**M1 Pacific Motorway extension to Raymond Terrace (SSI 7319)
Advice on the Environmental Impact Statement (EIS)**

Thank you for the request for advice from Public Authority Consultation (PAE-24749572), requesting the review by the NSW Environment Protection Authority (EPA) of the Environmental Impact Statement (EIS) for the proposed M1 Pacific Motorway extension to Raymond Terrace (Application SSI-7319).

ATTACHMENT A: EPA COMMENT ON EIS FOR M1 PACIFIC MOTORWAY EXTENSION TO RAYMOND TERRACE (SSI 7319)

B.2 Long term noise monitoring results

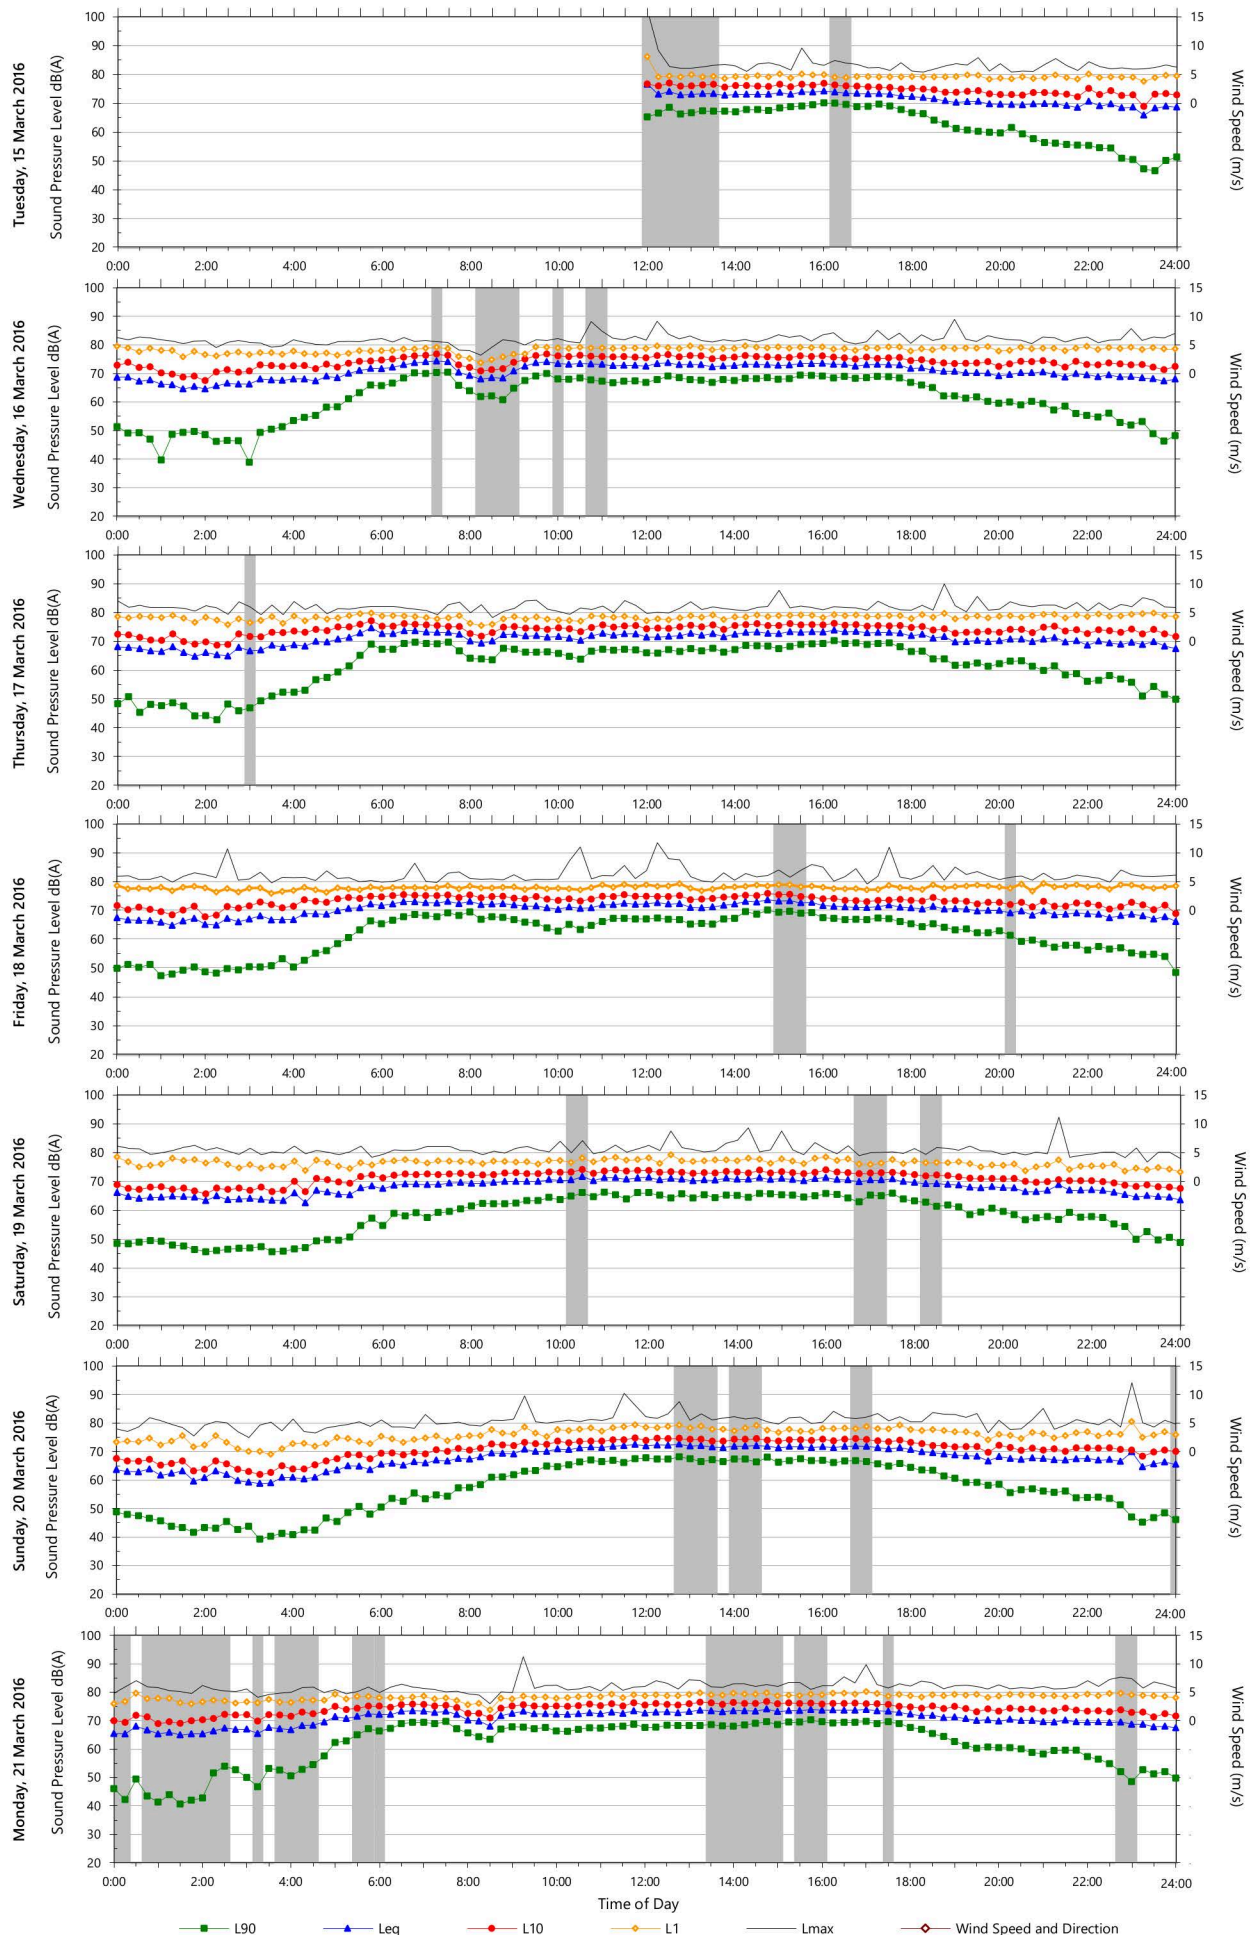
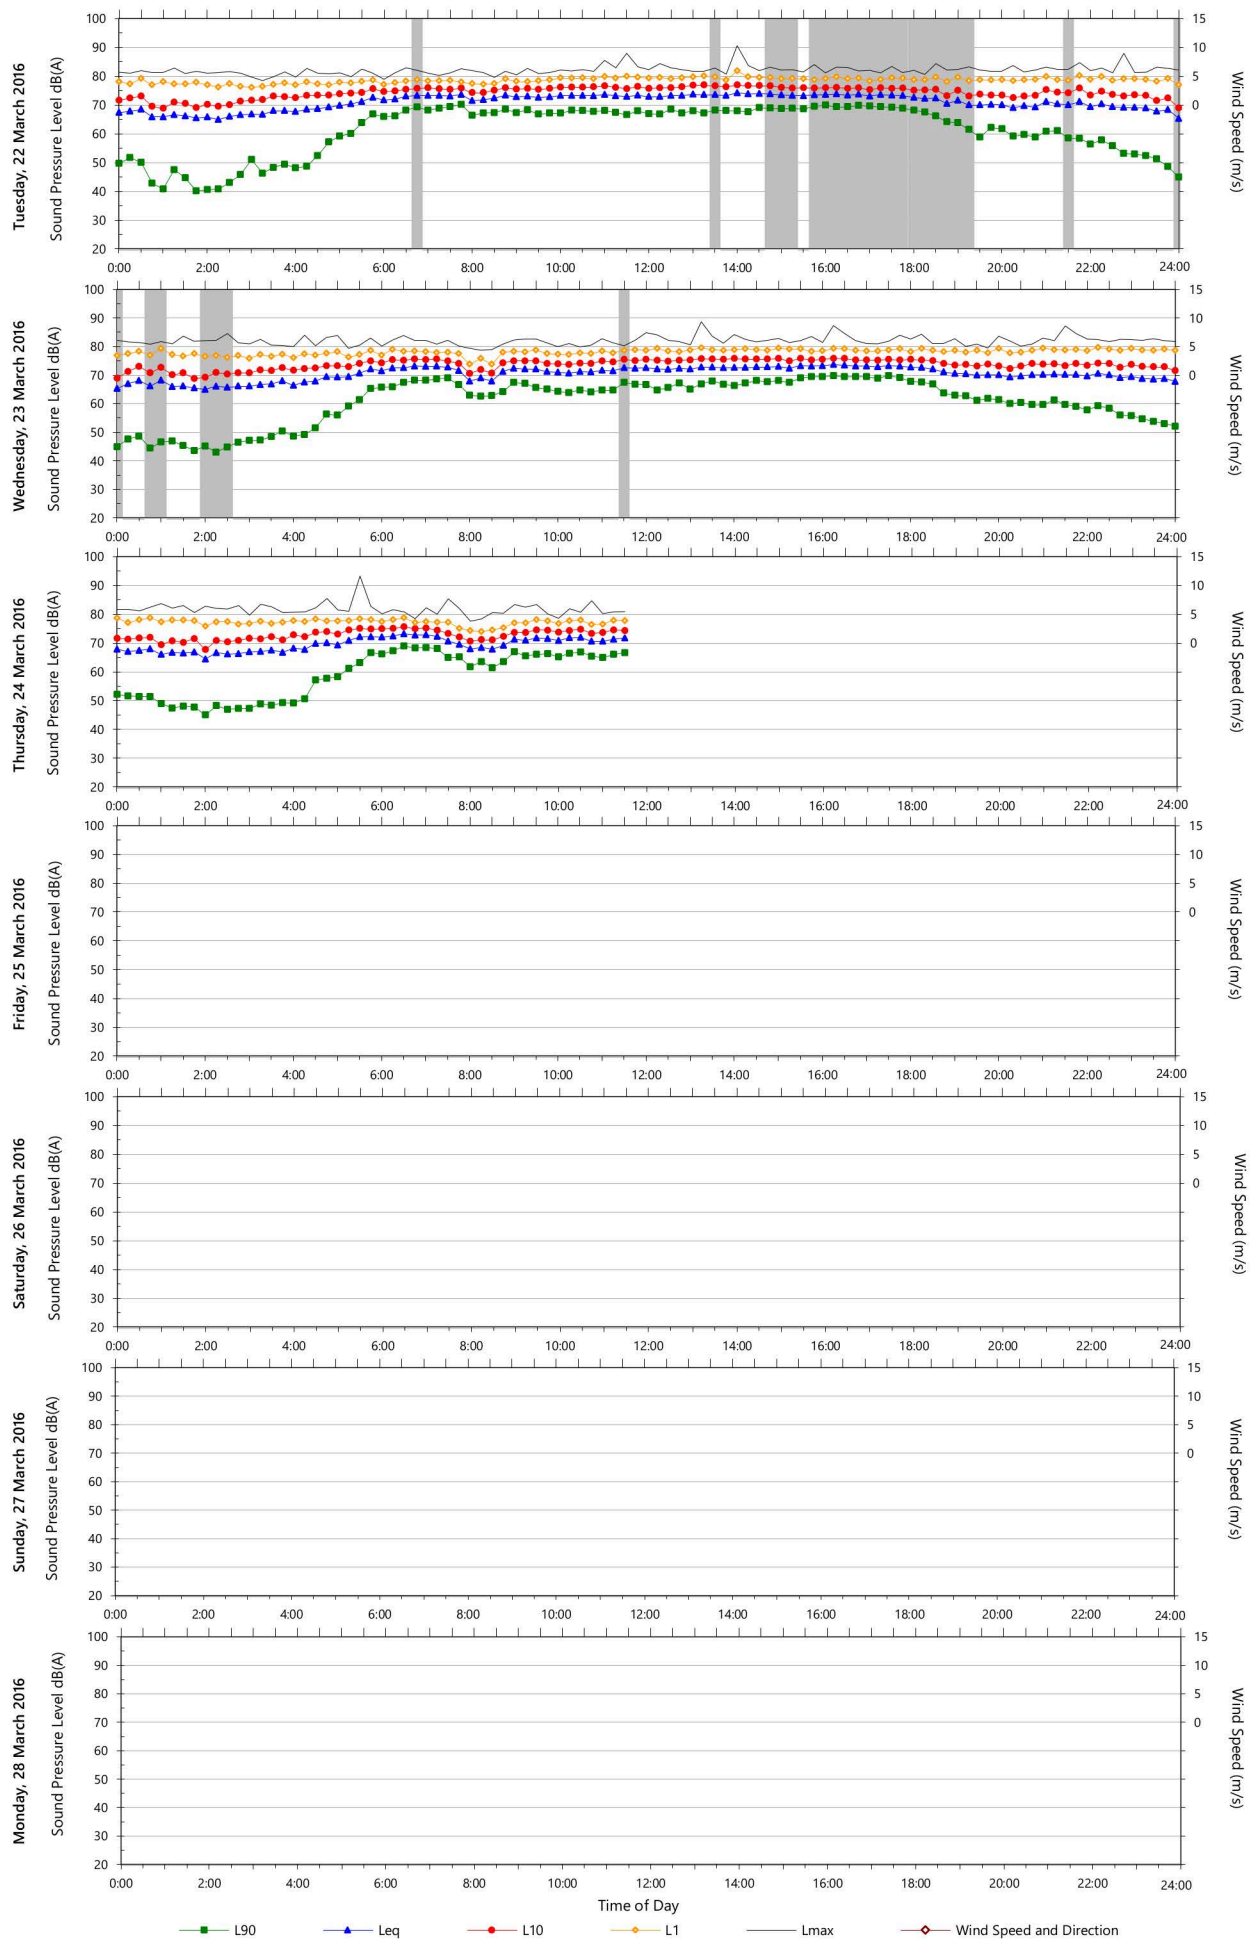
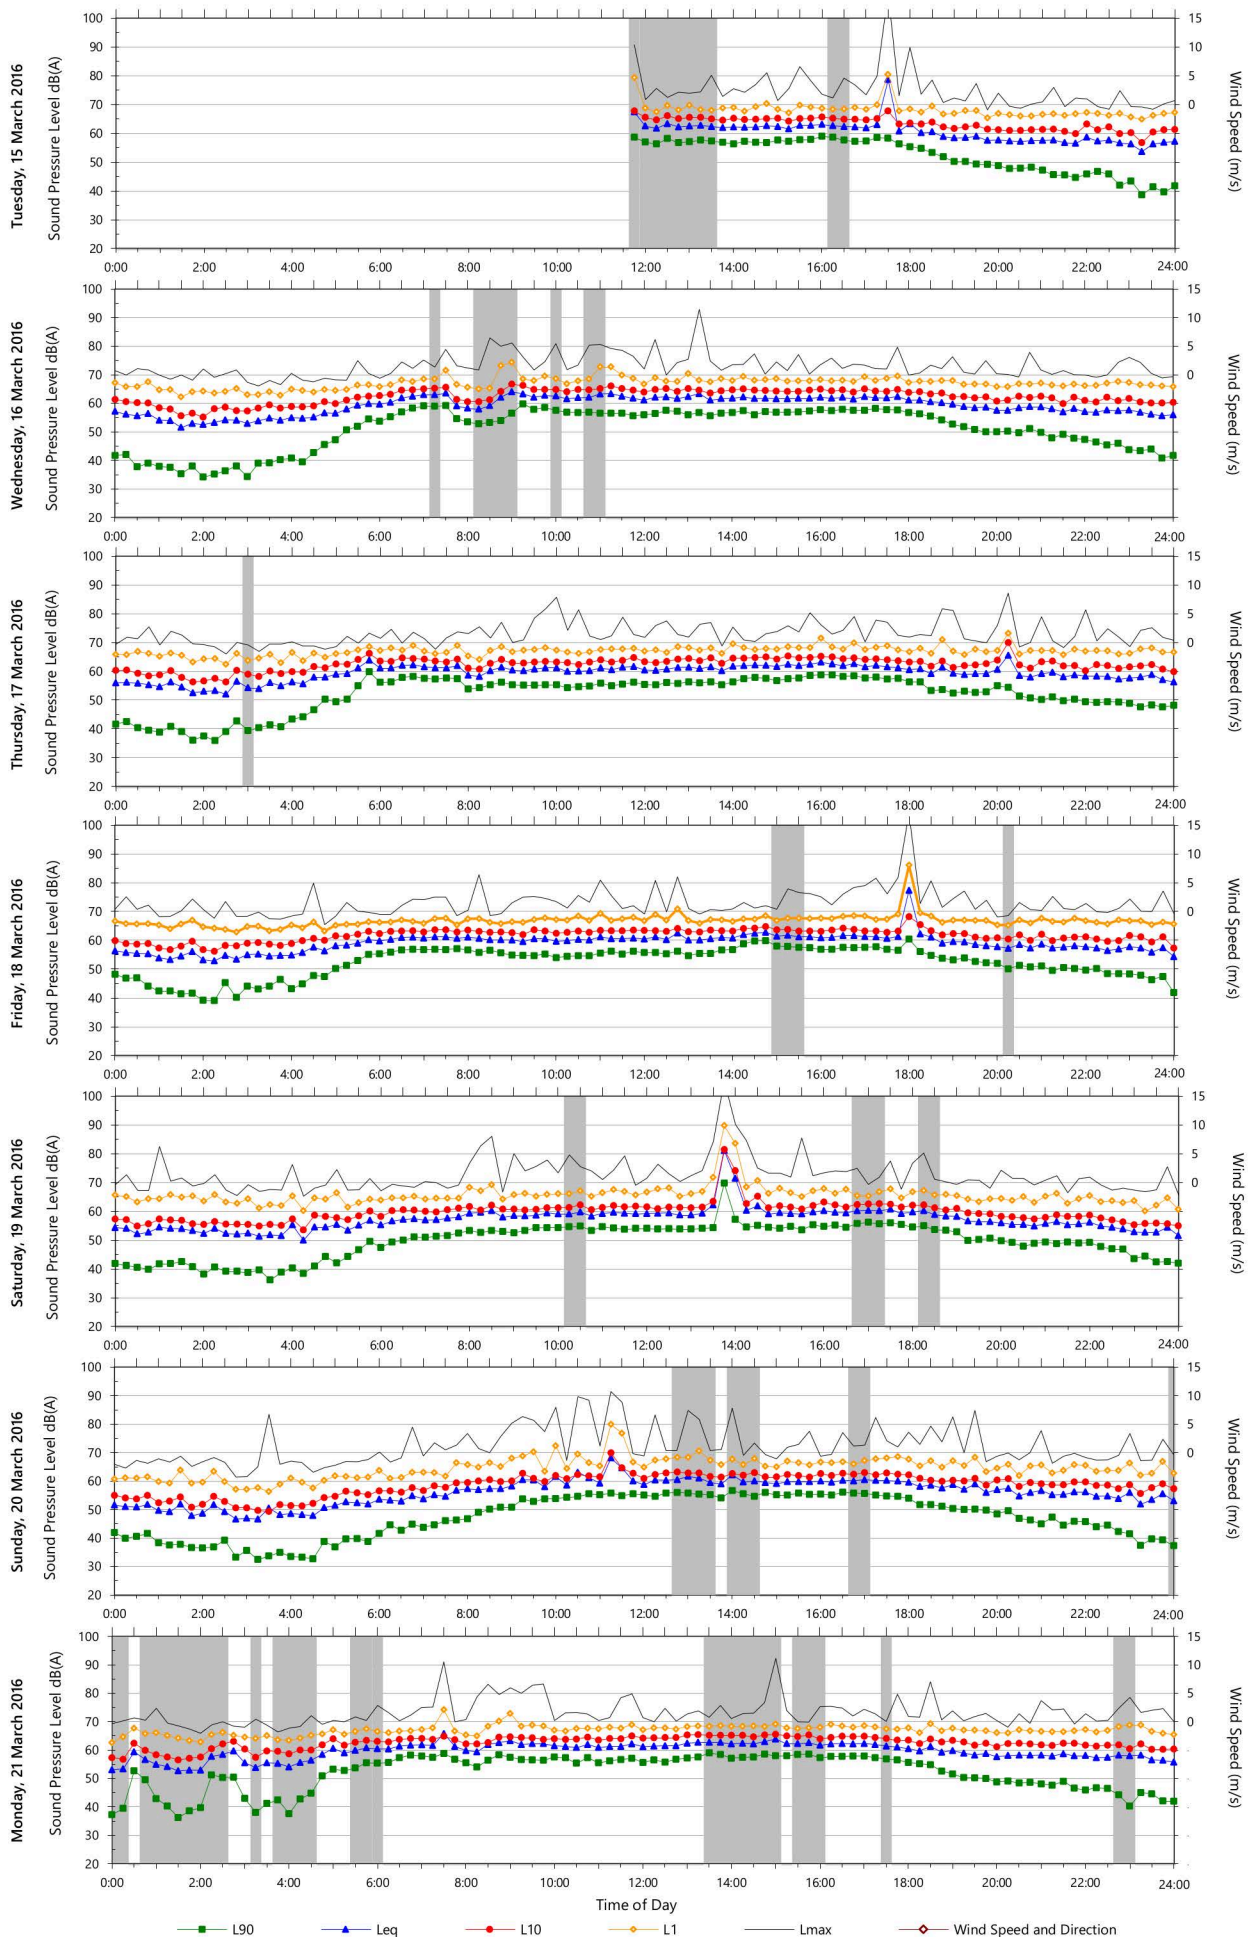
Locations L01 to L014 (inclusive) appear to have no more than 5 and in some cases less than 3 valid periods out of the total monitoring duration. Locations L15 to L20 appear to be less affected, however there it is still not clear if sufficient valid data has been presented.

Noise monitoring was also conducted in 2016 for the purposes of measuring road traffic noise. Due to the amount of data excluded at Locations L13 to L20, further justification is needed that the remaining data, after invalid samples were excluded, provides sufficient amount of data to enable a representative calculation of the traffic noise descriptors.

The proponent reviews the noise monitoring data in the NIA in the context of the monitoring requirements set out in the NPfI and for each location and either:

- Provide a justification and demonstrate that the requirements of the NPfl have been fulfilled; or
- Provide additional data that fulfills the monitoring requirements in the NPfl.

The EPA also recommends that the proponent either:

- Provides justification and demonstrate that the data presented for road traffic noise descriptors is sufficient to be representative; or
- Provides additional valid data.
